BCA ASSESSMENT REPORT

PROJECT: COLES EXTENSION

ADDRESS: M7 BUSINESS HUB OLD
WALLGROVE ROAD, EASTERN CREEK

Date: 11 February 2013

A DOCK OFFICE PLAN
- CDC EXPANSION

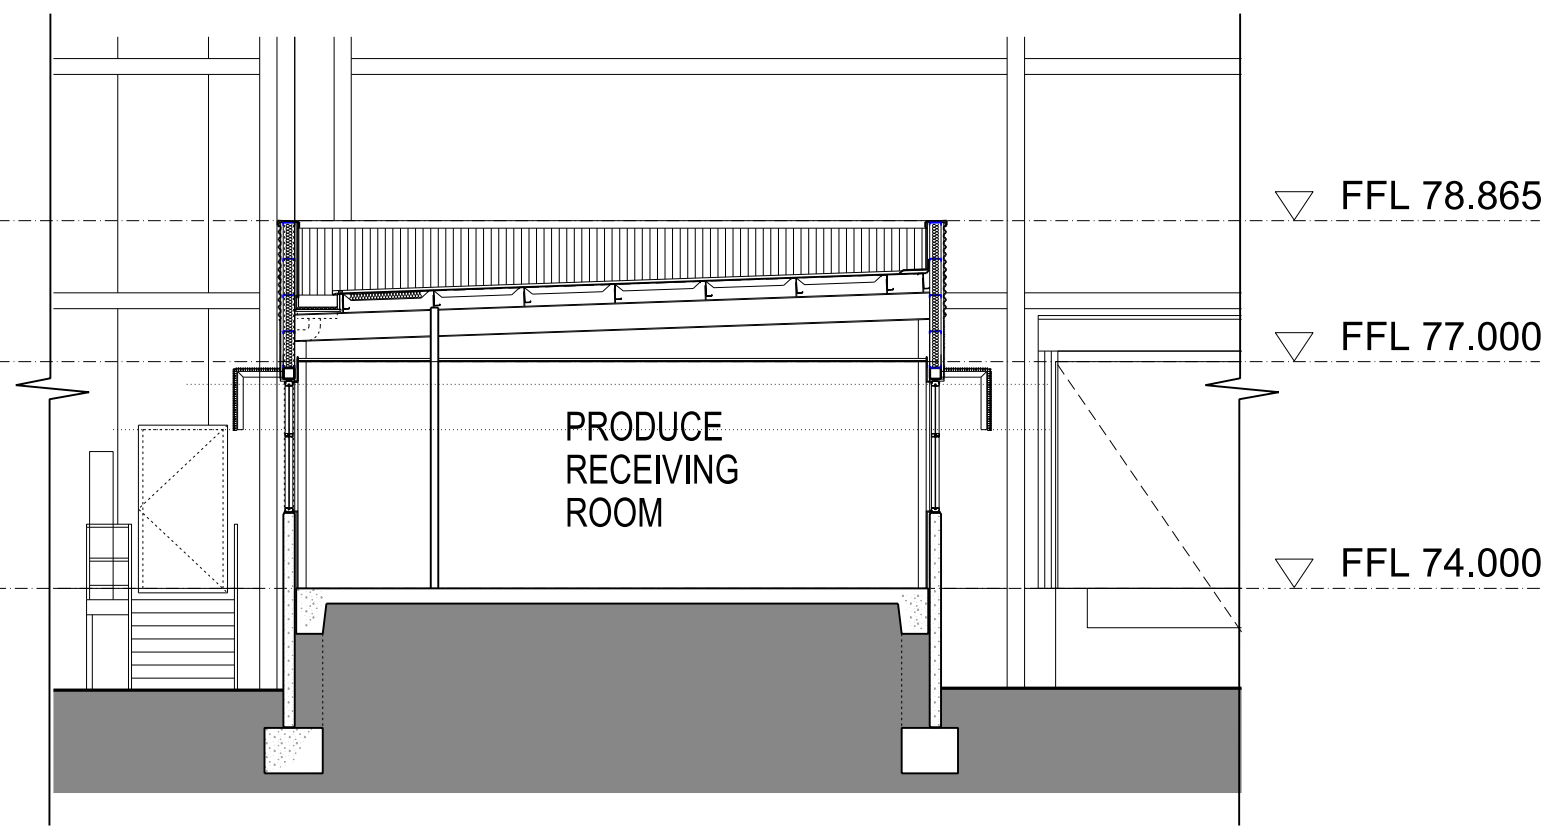
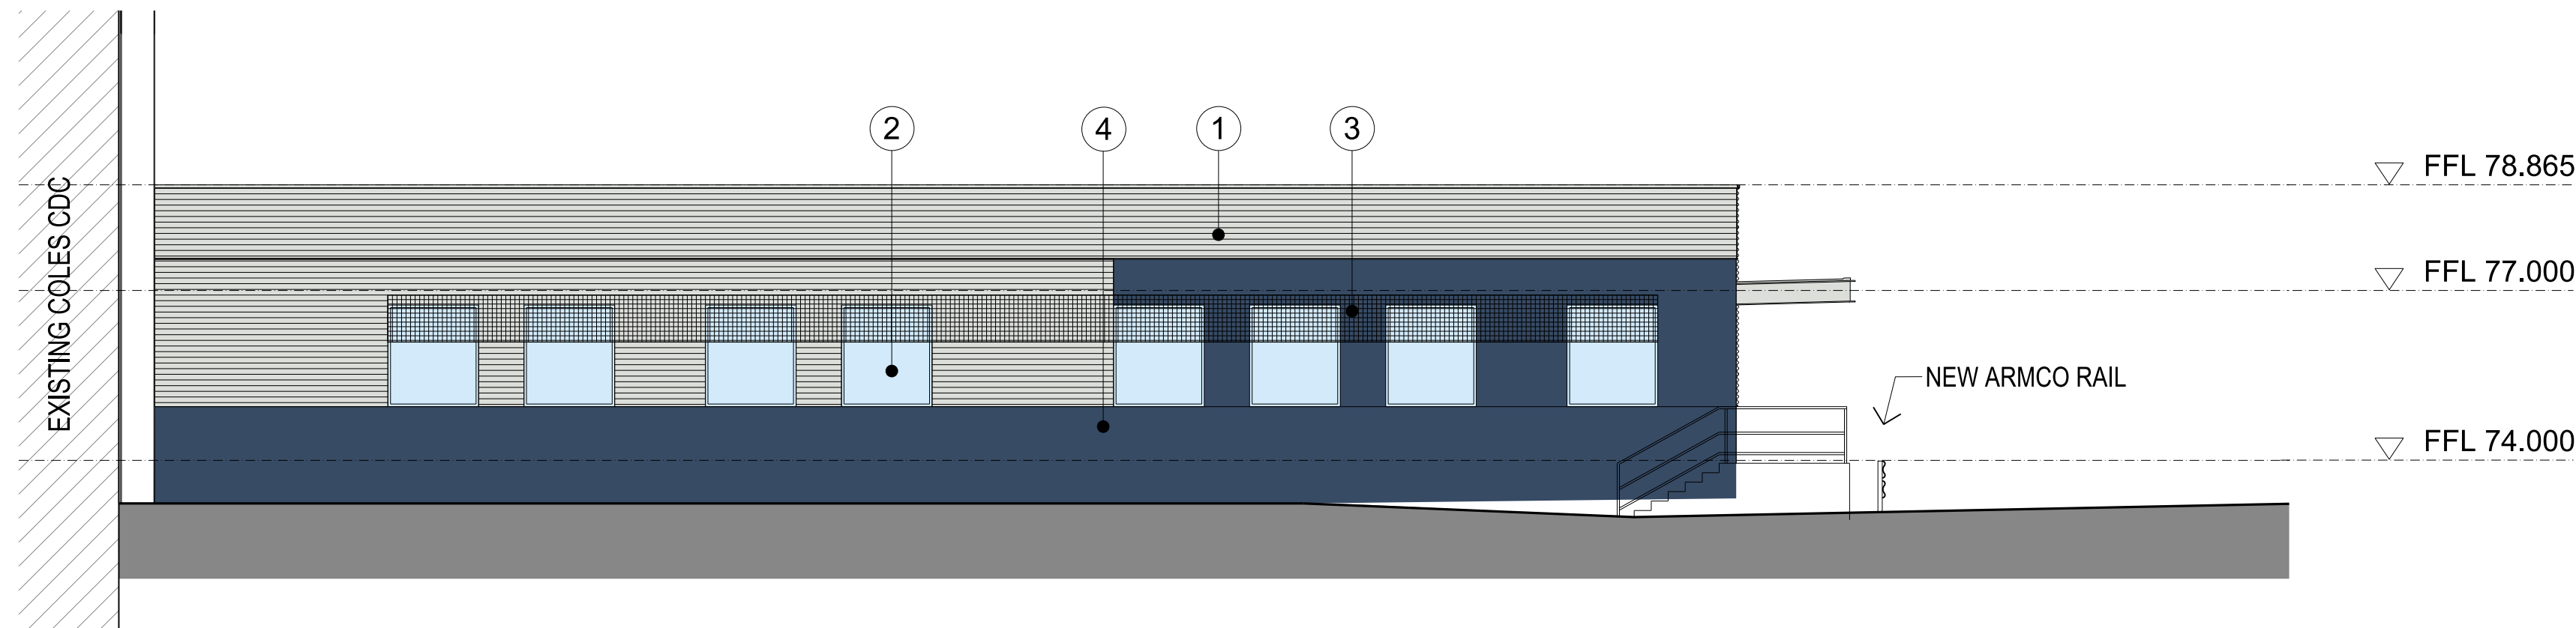
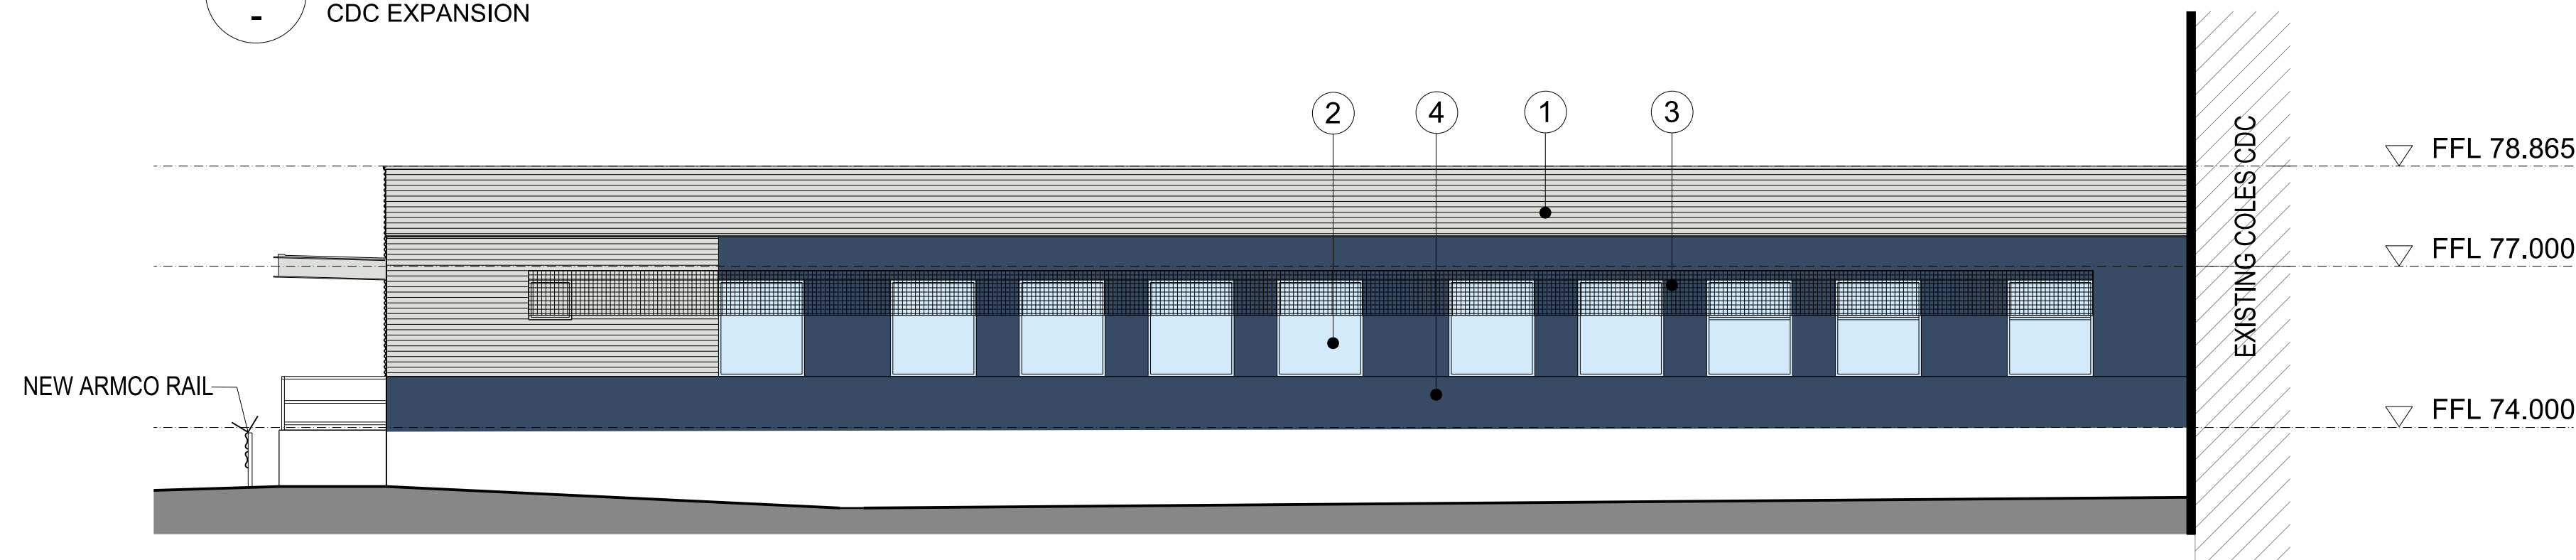
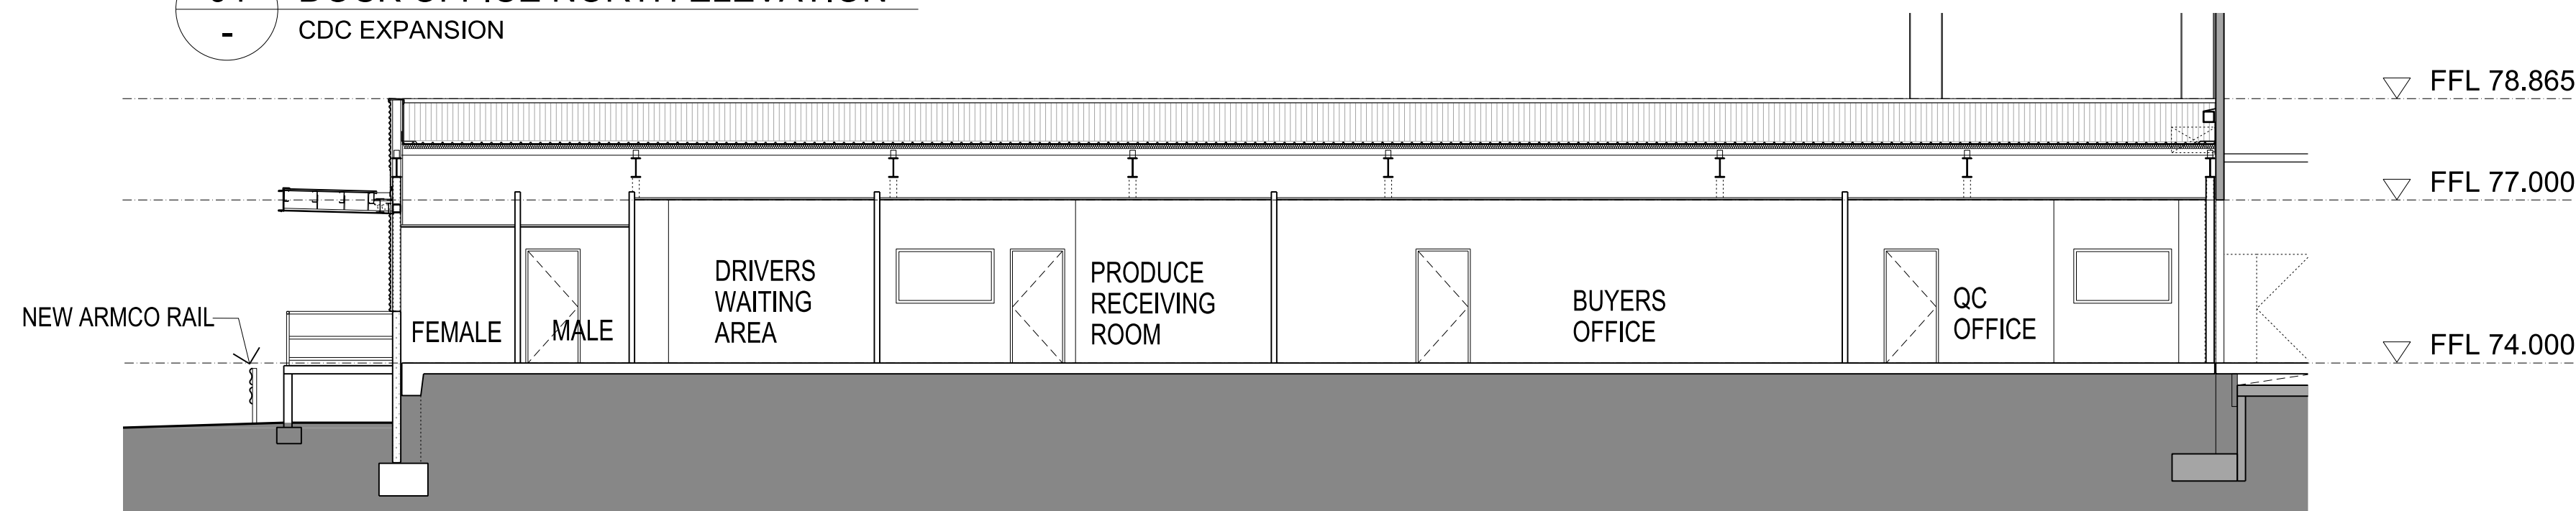
Comments: This requirement applies in relation to the new dock offices if any electrical distribution boards or Comms. equipment are to be installed.
